**Application: SSI 7485**

I write regarding the proposed modification to M4-M5 Link, Mod 2 The Crescent overpass and changes to pedestrian infrastructure in North Annandale, Rozelle and Rozelle Bay Foreshore area.

Figure 4-2 Pedestrian and cyclist bridge infrastructure options

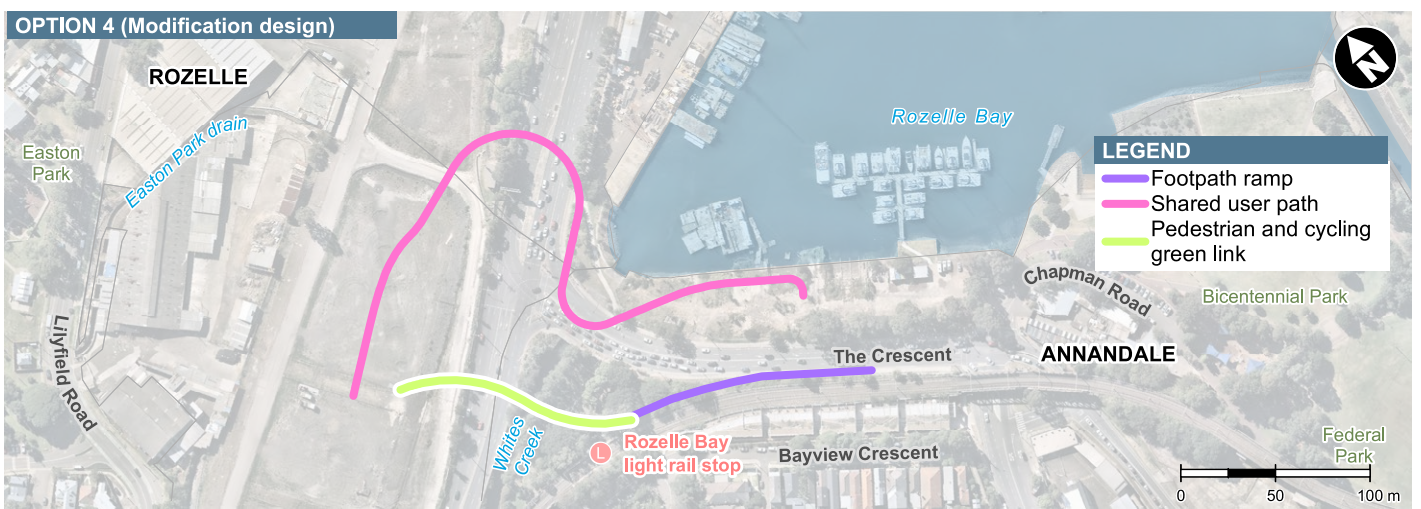
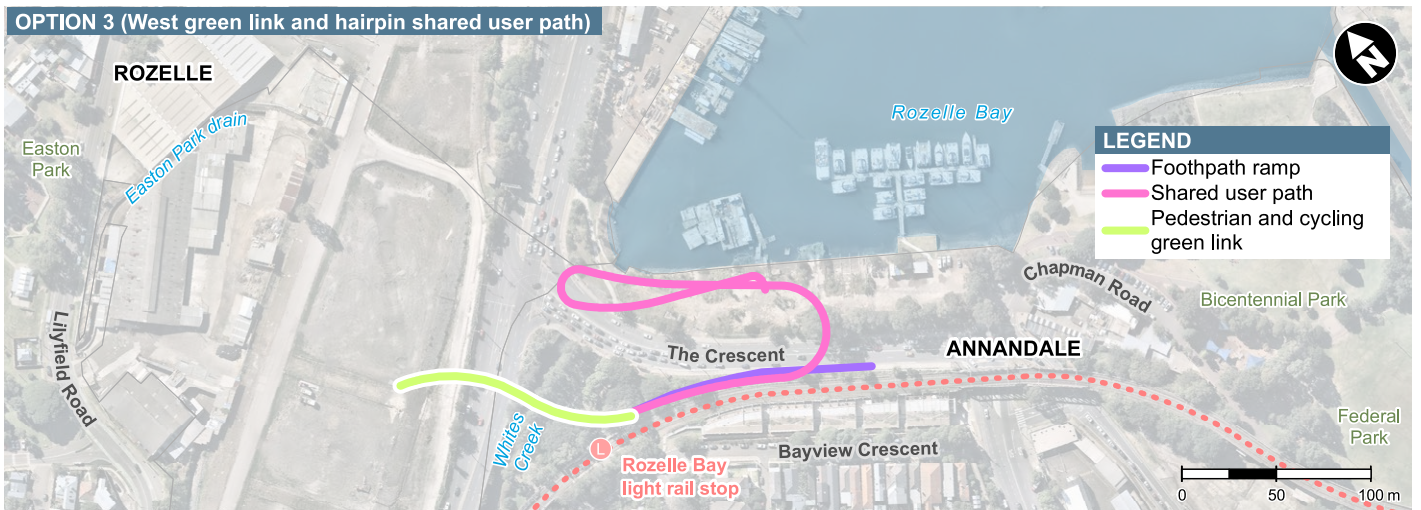
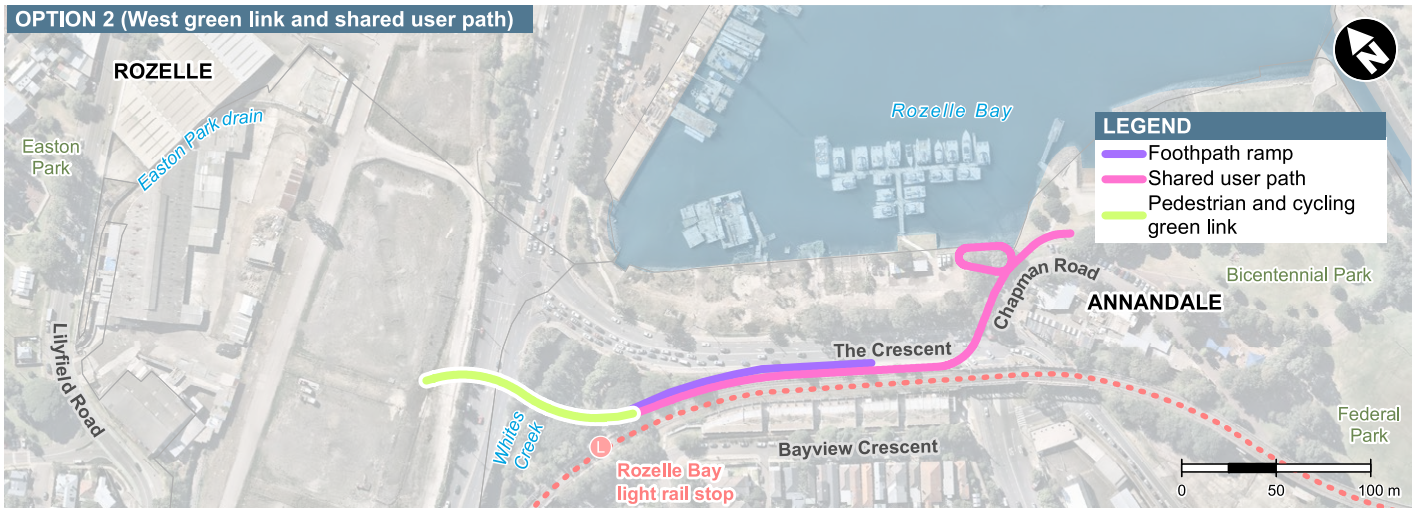
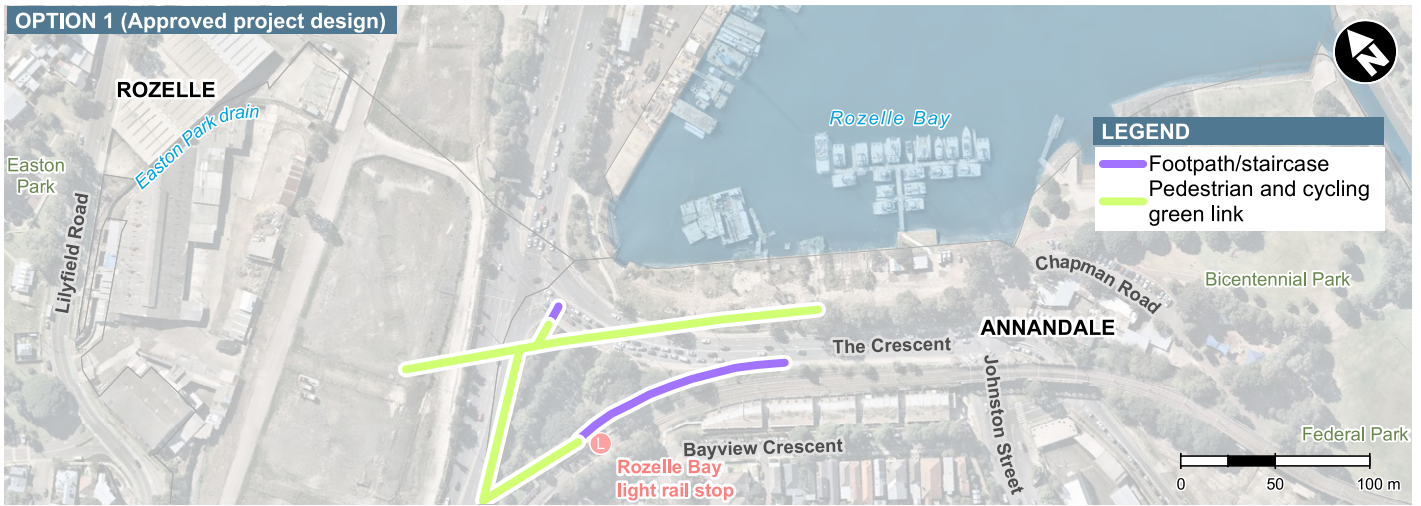
I request RMS work with the community to explore alternate design options to the proposed new car overpass design and the changed pedestrian and cyclist links. I am seeking the reinstatement of the safe, direct access from the approved EIS GreenLink to create a continuous green open space connection from the Rozelle Rail yards and Annandale to the foreshore. The GreenLink was more than just a walk way - it put people central to the design, maximising safety, and providing much needed accessible open space for the community now and into the future Bays Precinct design.

- The significantly reduced safety and increased risk for pedestrians and cyclists with removed access over The Crescent to Bicentennial Park and the increased traffic along Johnson Street.
- Being required to cross five sets of pedestrian lights at The Crescent as my option to reach the foreshore from Annandale or from Rozelle Bay light rail stop.
- Removal of direct active links to the foreshore, cutting the community off from the area and the proposed revitalisation of the entire Bays Precinct, including linking the Light Rail and Bus stops to a Ferry wharf and Metro station.
- Urban and landscape design that is being built before a finalised Masterplan for the area.
- Traffic changes that limit movements around the suburb and create further congestion in the local streets of Annandale, Forest Lodge, Glebe, Lilyfield and Rozelle with no planning to deal with these.

- Reinstate the GreenLink connecting communities and green open space from Rozelle to Bicentennial Park
- Relocate and design pedestrian and cyclist connections that are continuous, safe and direct.
- Design the modification infrastructure and active links in response to the character of the suburbs, the location of the foreshore and it's potential future development.
- Provide pedestrian and cyclist paths that maximise people safety and do not force them onto busier streets, unsafe concrete plazas and caged walkways.
- Integrate active and direct connections to all active transport - including the future Metro West and Foreshore Ferry Wharf
